From: Nicola Spencer <Nicola.Spencer@arun.gov.uk> on behalf of Planning.Responses <Planning.Responses@arun.gov.uk>
Sent: 28 April 2022 14:39
To: Iqraa Malik; Iqraa Malik
Subject: FW: Request for further information BN/55/22/HH
Attachments: 130 010 PLANS.pdf; 130 102 BLOC PLAN.pdf; 130 120 ELEV.pdf; 130 020 ELEVS.pdf; 130 110 PLANS.pdf

Drawing Title		
Block Plan as Proposed

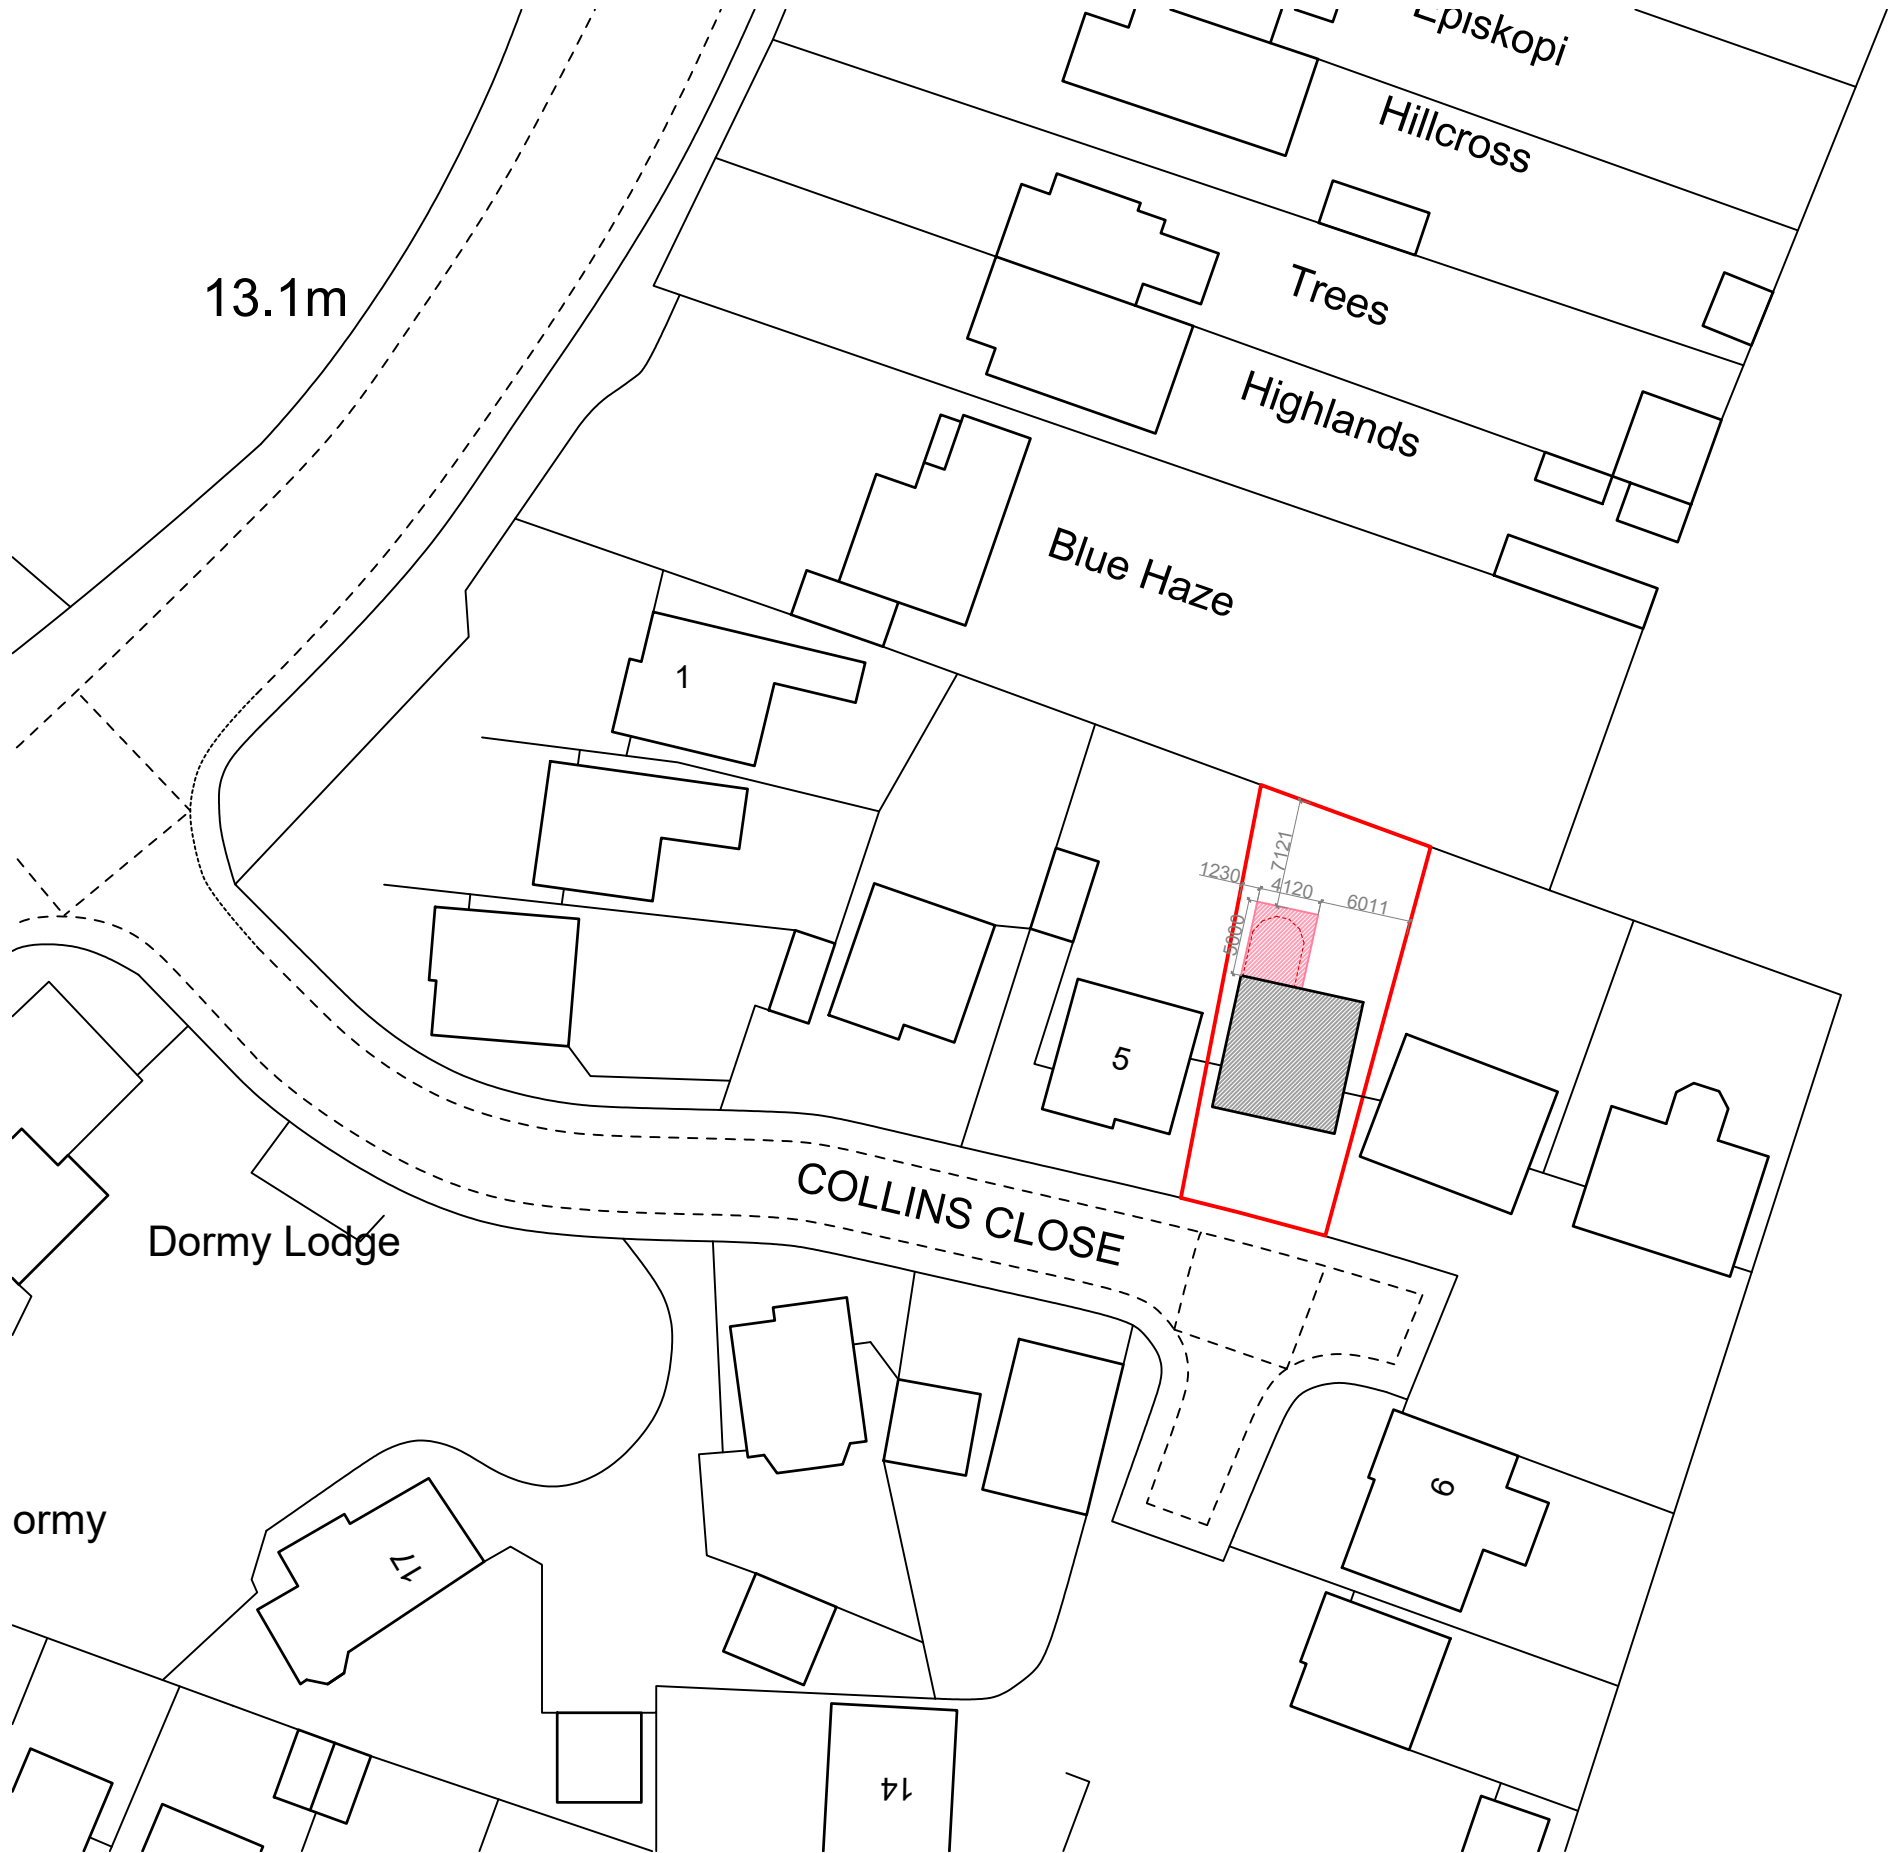
block plan - this is a scale drawing so all dimensions can be measured from the plan, but see attached for dimensions to all boundaries

Drawing Title
Floor Plans
as Proposed

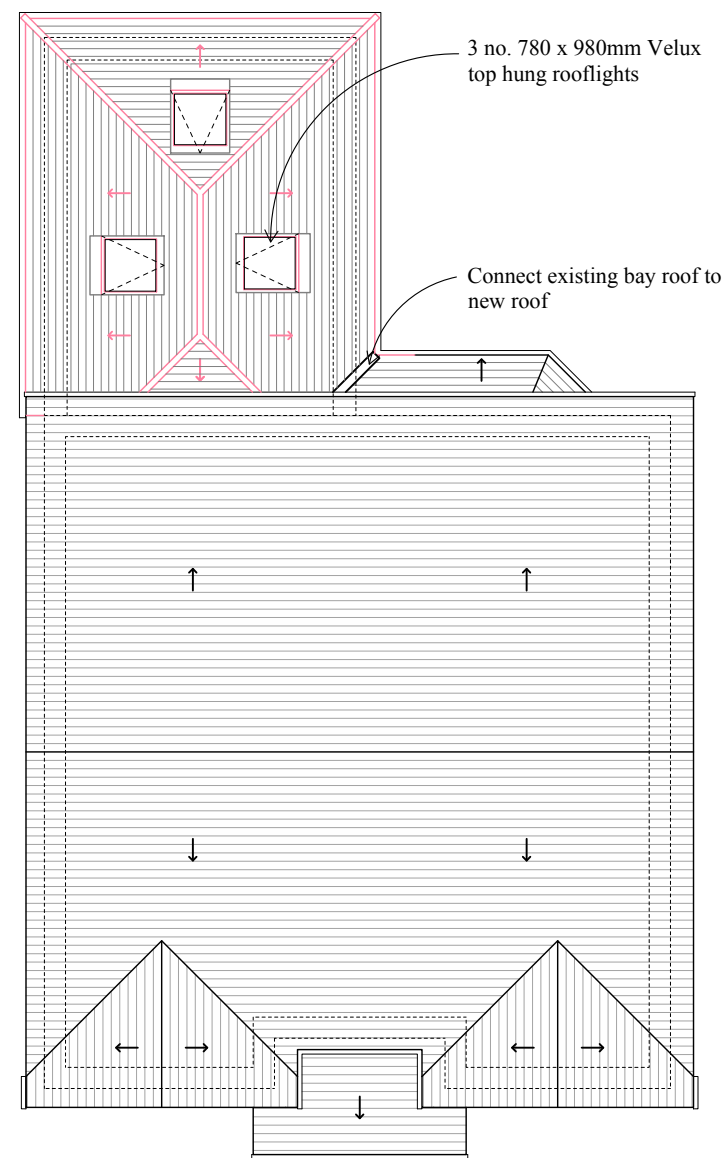
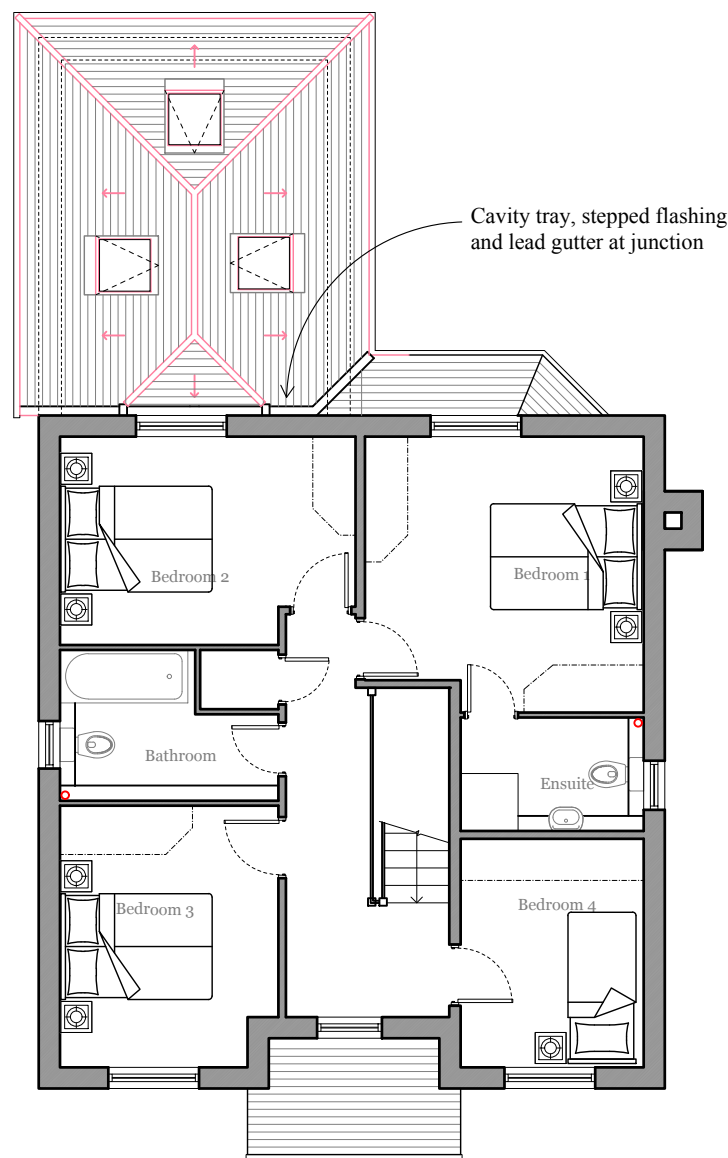
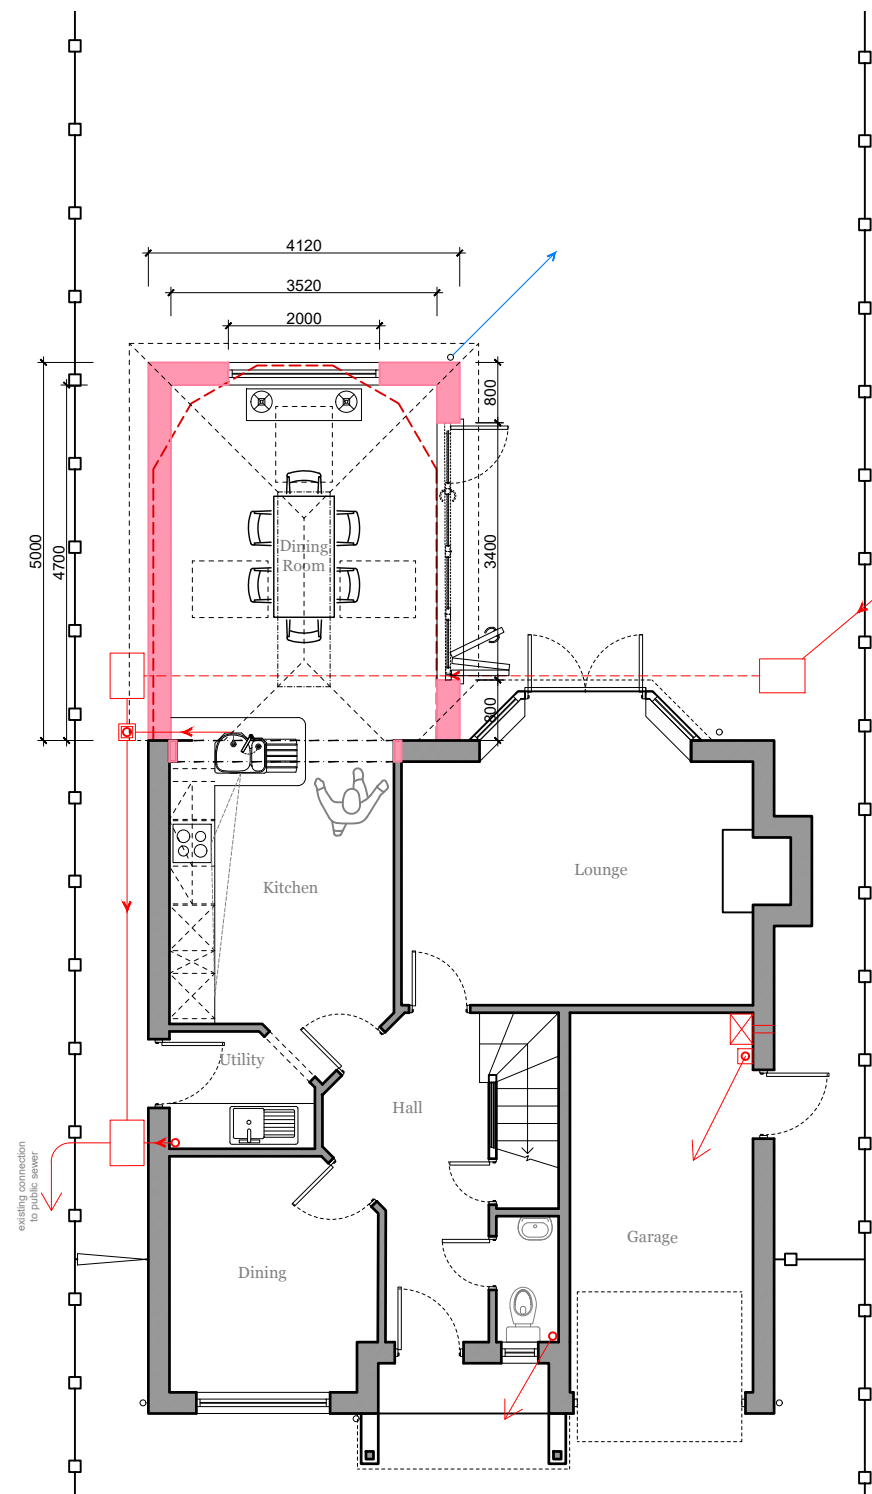
inconsistent plans/elevs - see attached, the front elevation does not form part of the application but has been amended nonetheless
